The following EIA scoping consultation responses were received after the consultation deadline specified under legislation and therefore did not form part of the Secretary of State's scoping opinion.

National Grid Bramford to Twinstead Tee 400kV Connection

Gestingthorpe Parish Council Response of April 2013, to the Feb 2013 ENVIRONMENTAL IMPACT ASSESSMENT SCOPING REPORT

TITLE: **2.11.1 Design and Layout Plans: Grid Supply Point Substation Layout**

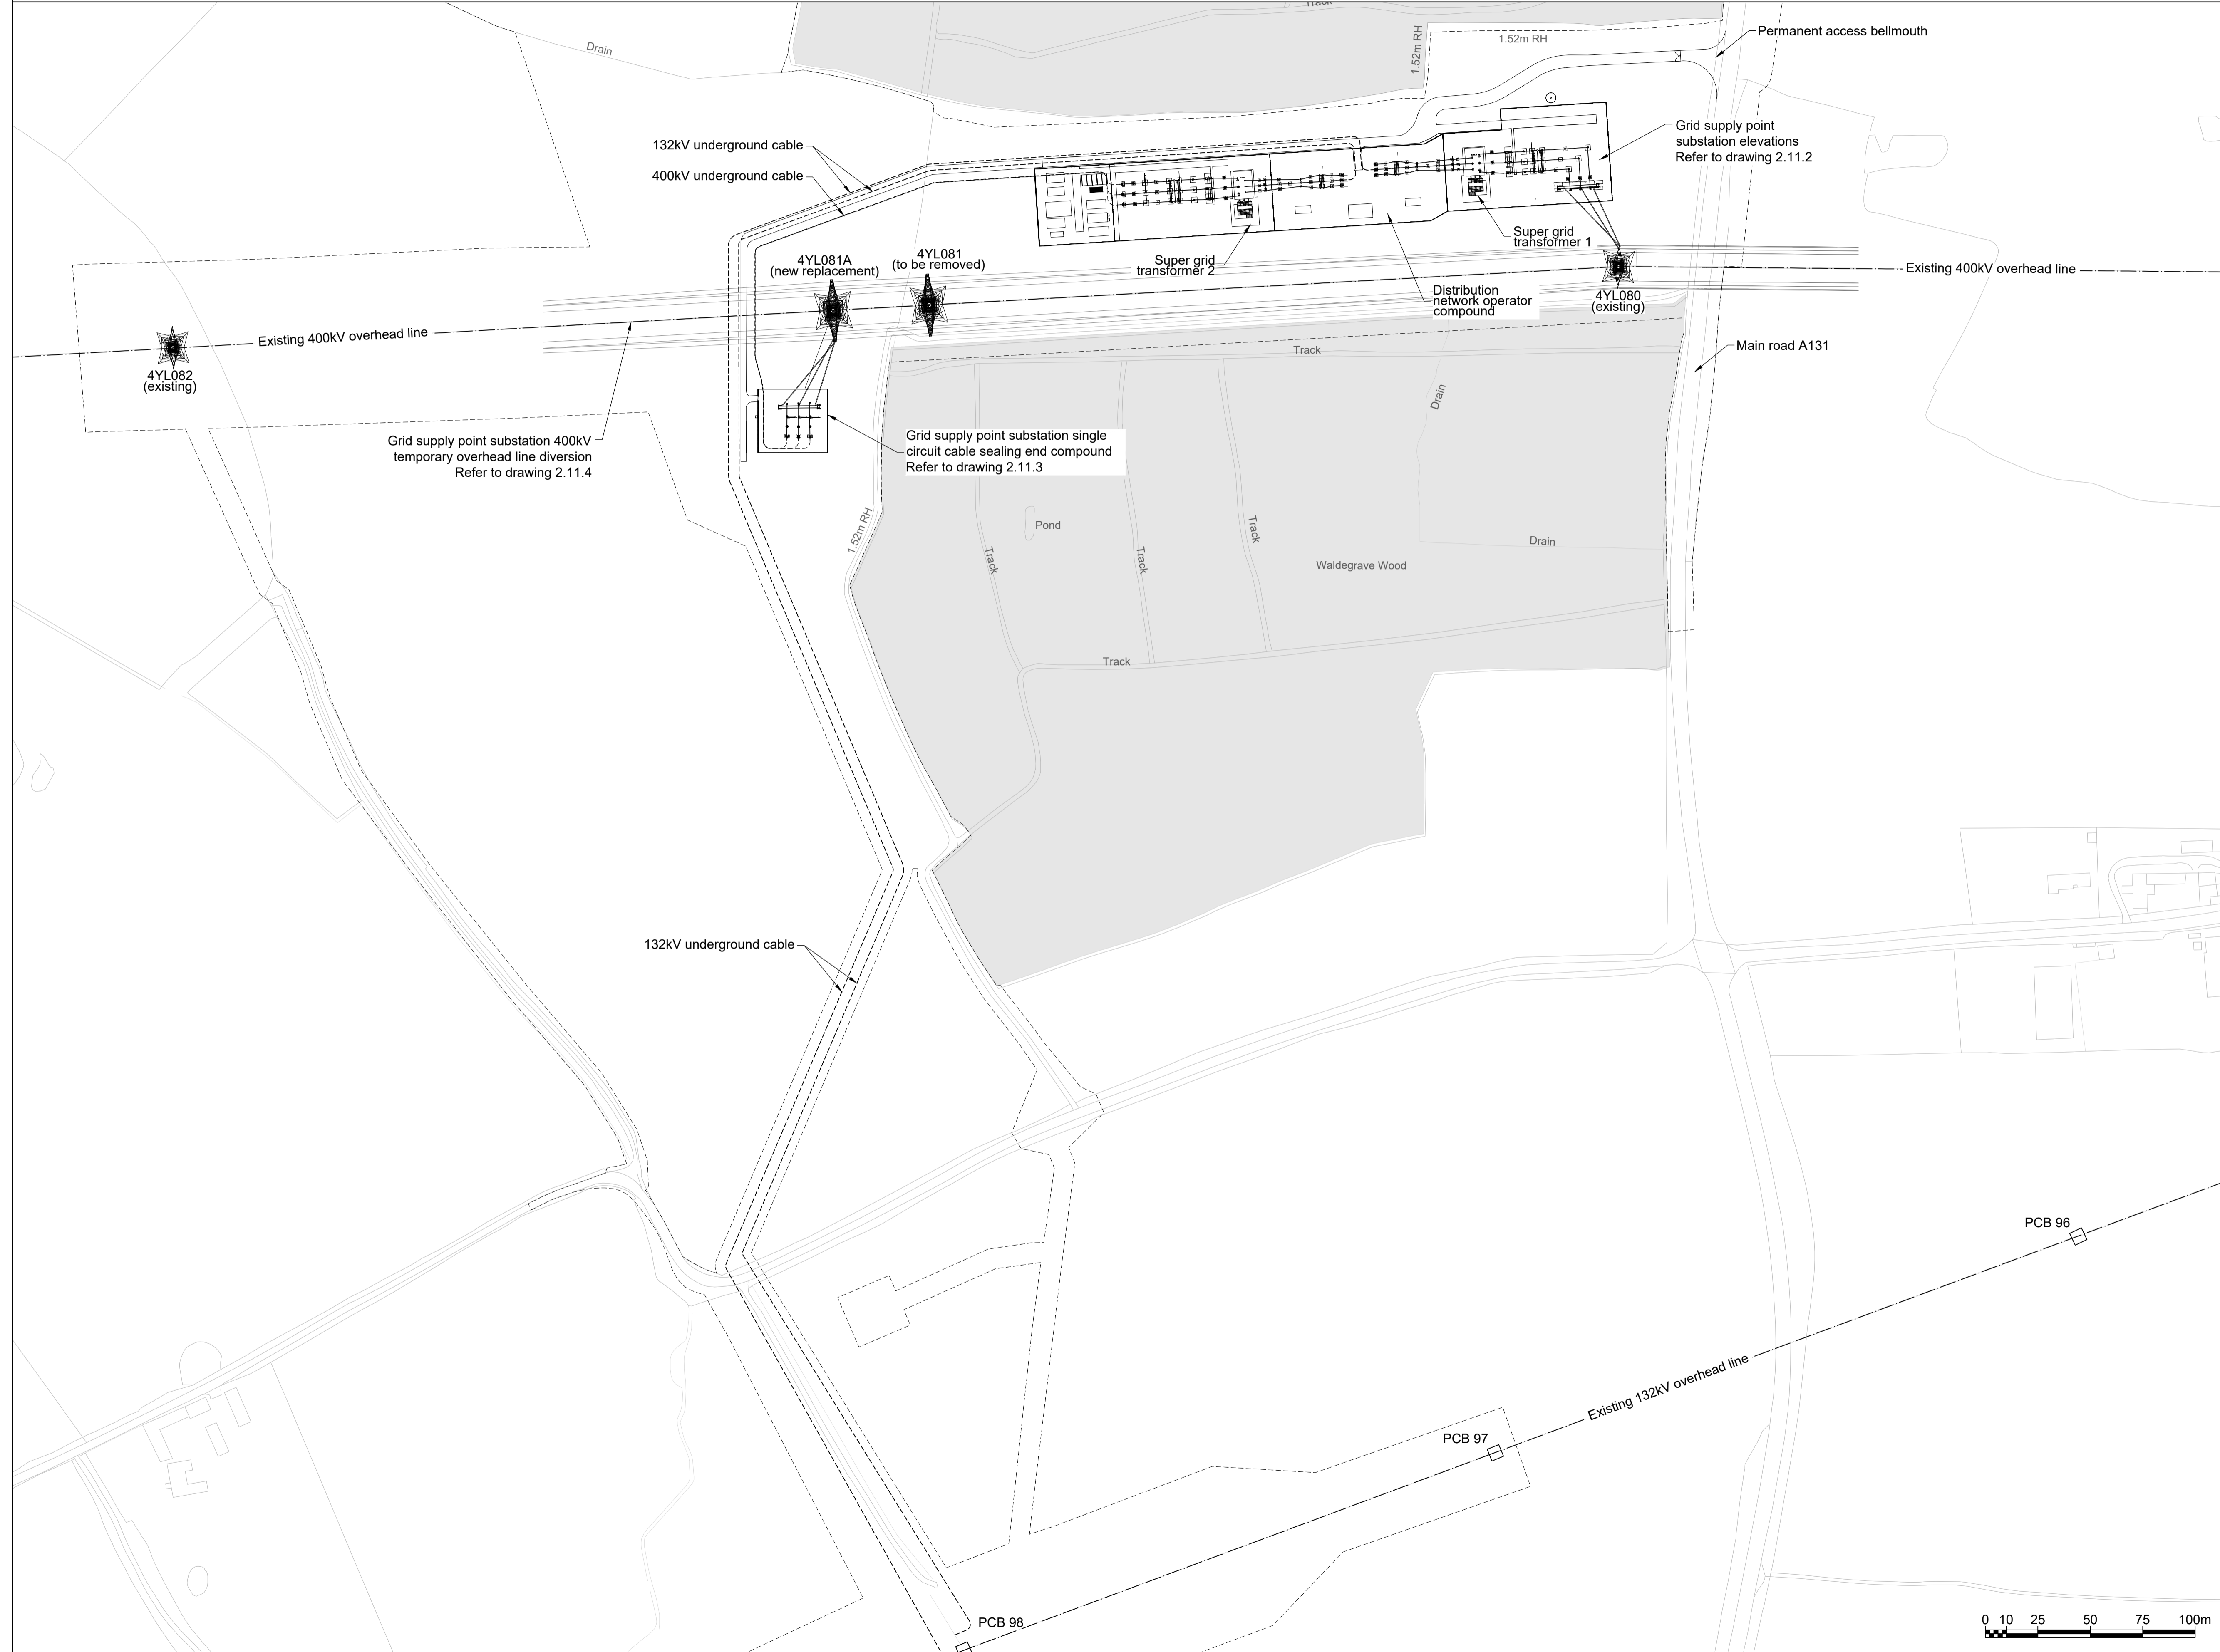
The Parish Council accepts that a local 400 kV to 132 kV transformer is the most obvious and effective solution electrically. However this is not the most satisfactory solution from a landscape point of view. It introduces a NEW highly visible incongruous element into a rural area. It will also introduce continuous noise into a quiet or very quiet area.

The Document is almost dismissive of operational noise, which will be continuous. There is anecdotal evidence to suggest that the local geology is such as to allow long distance ground propagation of low frequency noise. No geological information is given and there has been no ground transmission testing at the proposed sites.

Hence: at Substation Study Areas A and C at night it is generally quiet with intermittent vehicle noise, while at Substation Study Area B it is almost completely silent at night with very infrequent vehicle noise. It follows that the surrounding areas would be very sensitive to night time transformer hum. The area round site B, with its general tranquillity and exceptionally low night-time background noise would be very noise sensitive where it is close to the former B1056 and exceptionally noise sensitive further down Delvyns Lane, where the 3 dwellings within the Parish of Gestingthorpe are situated. Those suggested sites within the Area that are close to the three dwellings are totally unsuitable on noise grounds.

There needs to be proper assessment of the sound transmission properties of ground. There must be rejection of any of these Study Areas for which appropriately designed vibration insulation between the transformers and the ground cannot assure sound levels that are negligible compared to night-time background noise.

The need for a diesel generator to operate switchgear, monitoring and communications equipment in the event of power loss is accepted as its use would only be in major emergencies. However the construction of standby generation to supplement the Grid supply during times of low renewables about is totally unacceptable at any of the locations under consideration. Such future additions should be specifically excluded.

A reduction in the landscape degradation can be achieved by suitable design, including symmetrical down cabling and 400 kV switchgear, by minimising the clutter within the compound by siting most of it in a single building and by choice of perimeter fencing.
